Dean Moor Solar Farm

Applicant Responses to ExA's Written Questions (2) on behalf of **FVS Dean Moor Limited**

28 October 2025
Prepared by: Broadfield
PINS Ref: EN010155
Document Ref: D4.3
Deadline: 4
Revision: 1

DEAN MOOR SOLAR FARM
APPLICANT'S RESPONSES TO EXA'S WRITTEN QUESTIONS (2)
PLANNING INSPECTORATE REFERENCE EN010155
PREPARED ON BEHALF OF FVS DEAN MOOR LIMITED

ES Figure 2.1 Cumulative Schemes within 10km of Order Limits

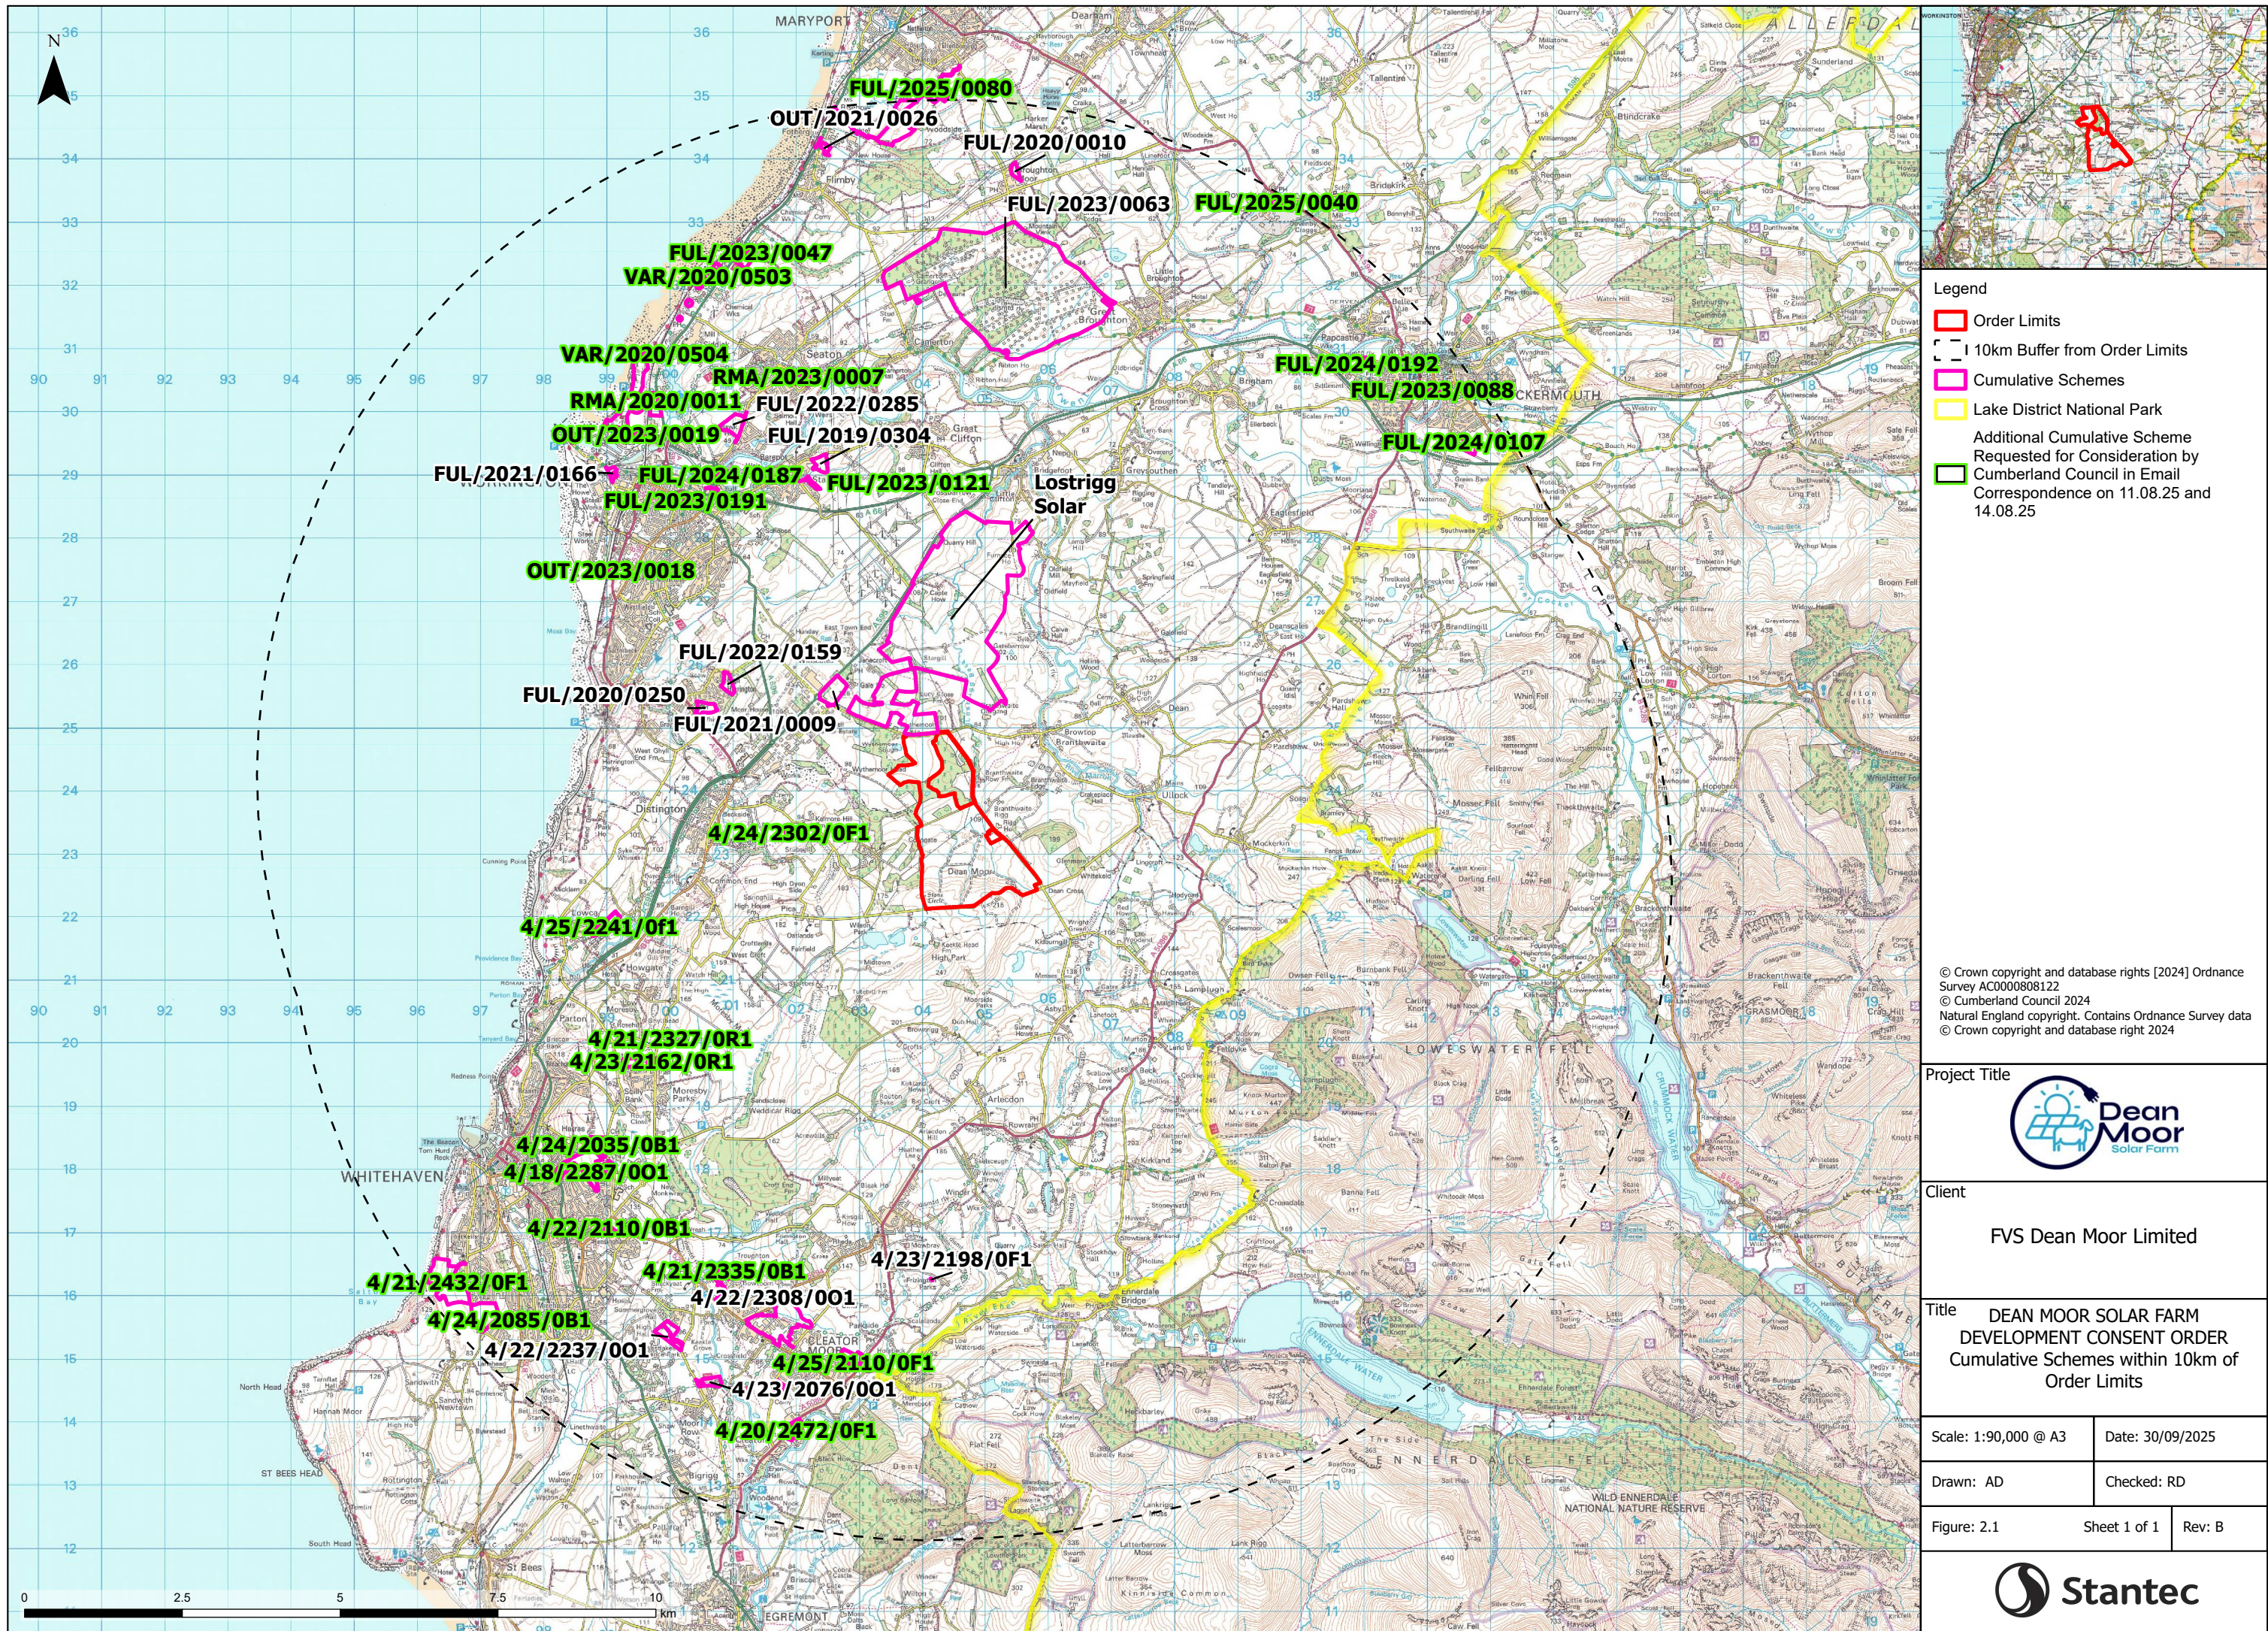
No.	Question / Applicant's Response
Q2.3.1	<p>Question: <i>Cumulative effects – the applicant should update SoCGs in order to ensure that the latest position as set out in the additional cumulative schemes table 1.1 [REP3-008] is properly understood and considered in relation to specific topics. [Addressed to the Applicant and relevant interested parties]</i></p> <p>Response:</p> <p>A 'Cumulative Assessment Note', as a technical note (TN), submitted as Appendix A of the D3 ARLIR [REP3-008]. The TN considered the Proposed Development's likely significant cumulative effects when considered against an additional 31 cumulative schemes requested for consideration by the Council in email correspondence on 11 and 14 August 2025, in the context of the cumulative schemes already assessed as set out in ES Chapter 11 - Cumulative Effects and Residual Effects Summary [APP-042] for likely significant cumulative environmental effects with the Proposed Development.</p> <p>The conclusions of the Cumulative Assessment Note confirm that, taking into consideration the additional 31 cumulative schemes there is no change to the cumulative assessment provided by ES Chapter 11, and there are no likely significant cumulative effects resulting from the Proposed Development and these schemes requiring them to be 'scoped-in' to ES Chapter 11.</p> <p>This TN was shared with the Council in advance of D3 and the outcomes discussed as part of the dSoCG process. The Council's acknowledgement of the Applicant's consideration of the additional schemes and agreement as to the conclusions of the TN are reflected in and CC.LPA.7 in the D3 dSoCG [REP3-019]. The Council have indicated that the conclusions of the TN, that these additional cumulative schemes do not result in further significant cumulative effects requiring consideration within the applications' ES are robust within the D4 dSoCG [D4.10].</p> <p>It is considered that, if the Council had any concerns about any specific schemes which are coming forwards, they would have raised them through the topic-specific discussions which took place with each of the Council's departments. However, no such concerns were raised, and beyond the agreement at CC.LPA.7, topic specific agreement on the residual cumulative effects is captured by the rows 'matters agreed' rows for landscape (CC.L.3 and 12), ecology (CC.EC.4), and transport (CC.LHA.10). However, it is acknowledged that the language within CC.LPA.7 was not as clear as it could be on this matter and therefore this row of the dSoCG has been updated to provide greater certainty [D4.10].</p> <p>Given that there are no likely significant cumulative effects resulting from the Proposed Development and these schemes, it has been determined that they do not need to be scoped-in to the ES, and therefore the list of additional schemes provided by the Council in August do not need to be shared</p>

No.	Question / Applicant's Response
	<p>with consultees to inform any updates to dSoCGs, as there are no new effects for which consultation may be relevant. And, the TN was published at D3 and is therefore available to consultees with whom the Applicant is regularly engaging, and who have not raised cumulative schemes as a matter requiring further discussion. Whilst the Applicant will remain open to continual engagement with all consultees on cumulative impacts or any other matters it is not intended to seek to update dSoCG with consultees other than the Council due to the lack of cumulative effects as established by the TN and affirmed by the Council.</p>
Q2.3.2	<p>Question: <i>Please clarify whether you are satisfied with the applicant's updated appraisal of relevant schemes to be considered cumulatively as set out in appendix A (cumulative assessment note) of the applicant response to Cumberland Council's response to ExA's first written questions [REP3 008], and the associated documents. [Addressed to the Council]</i></p> <p>Response:</p> <p>This question is for the Council and the Applicant's understanding of the position as it relates to this question is set out in response to D2.3.1.</p>
